**Town & Country Planning Act 1990 (as amended)
Town and Country Planning (Development Management Procedure) (England) Order 2015
Application for Full Planning Permission**

Development Change of use from garage & vehicle hire company to vehicle hire branch including the demolition of existing building to replace with modular unit. This application may affect the setting of a listed building.

Location Bruce Dixon South Bersted Garage Shripney Road Bognor Regis

Thank you for the information you have sent following my previous letter. Unfortunately I am still unable to accept the application as valid until the following items are received or resolved:-

Drawing: Proposed Site Plan

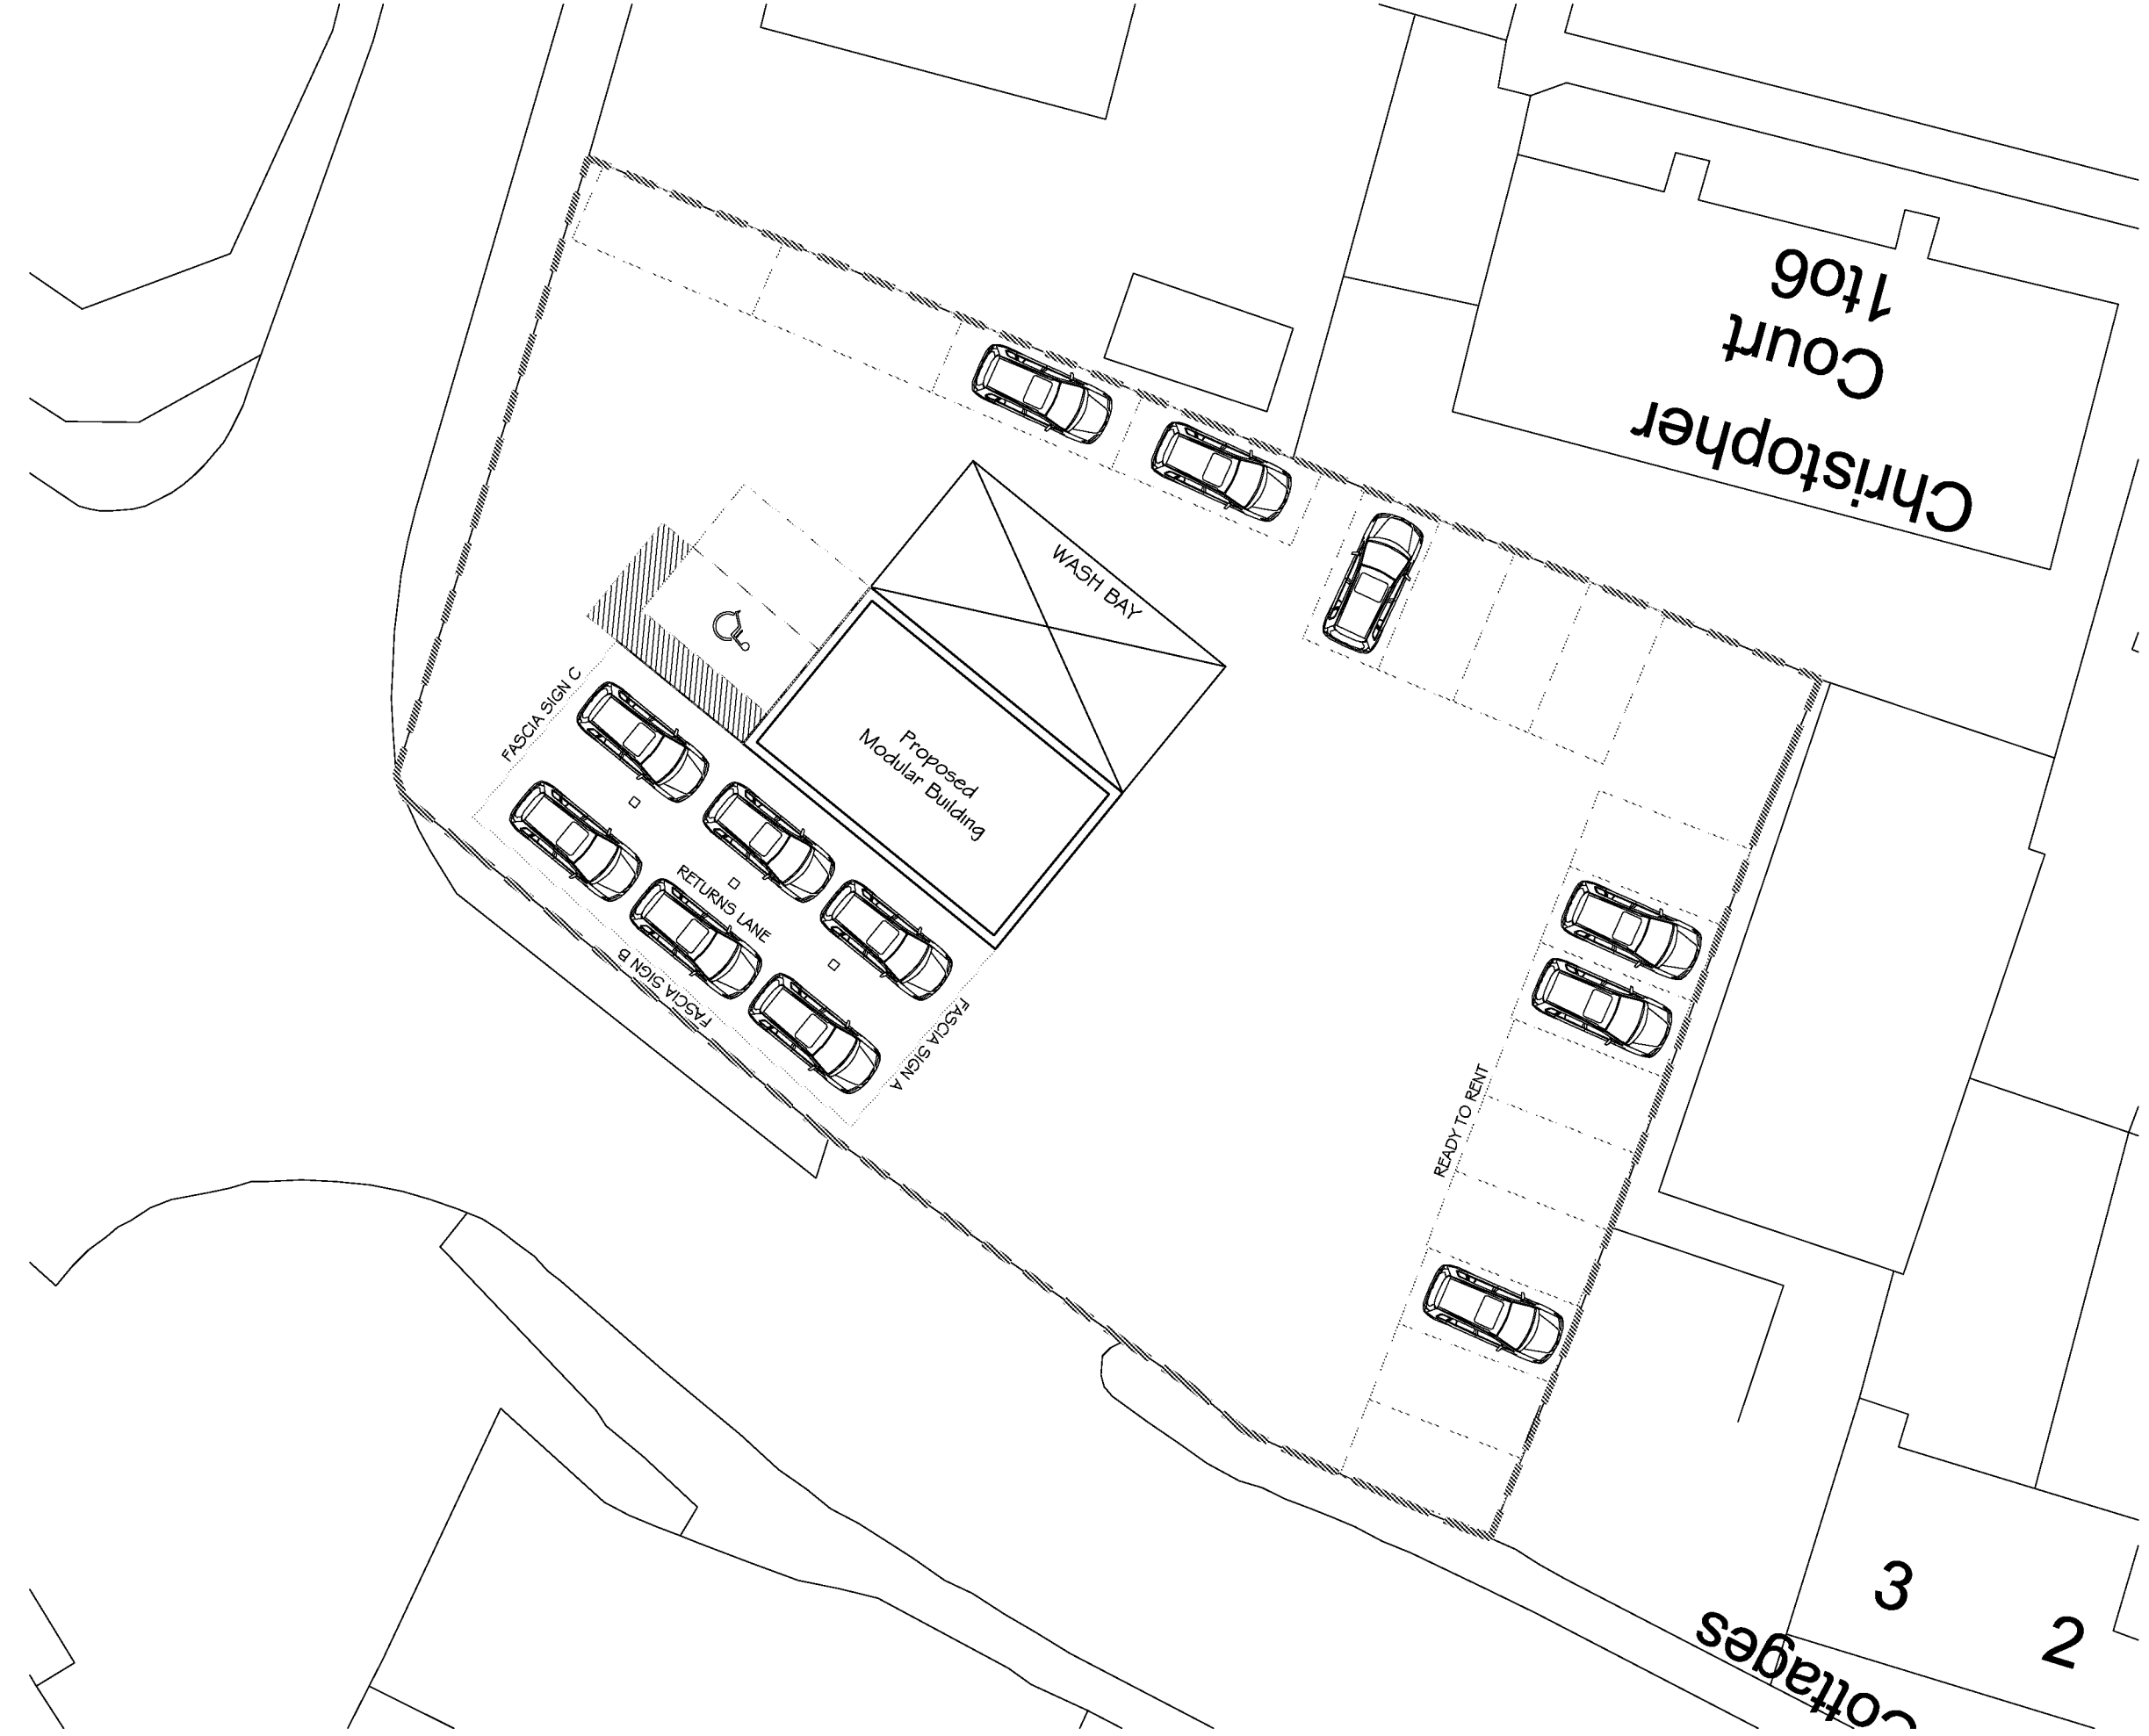
On the proposed site plan, please indicate that the canopy is to be retained.
Flood Risk Assessment
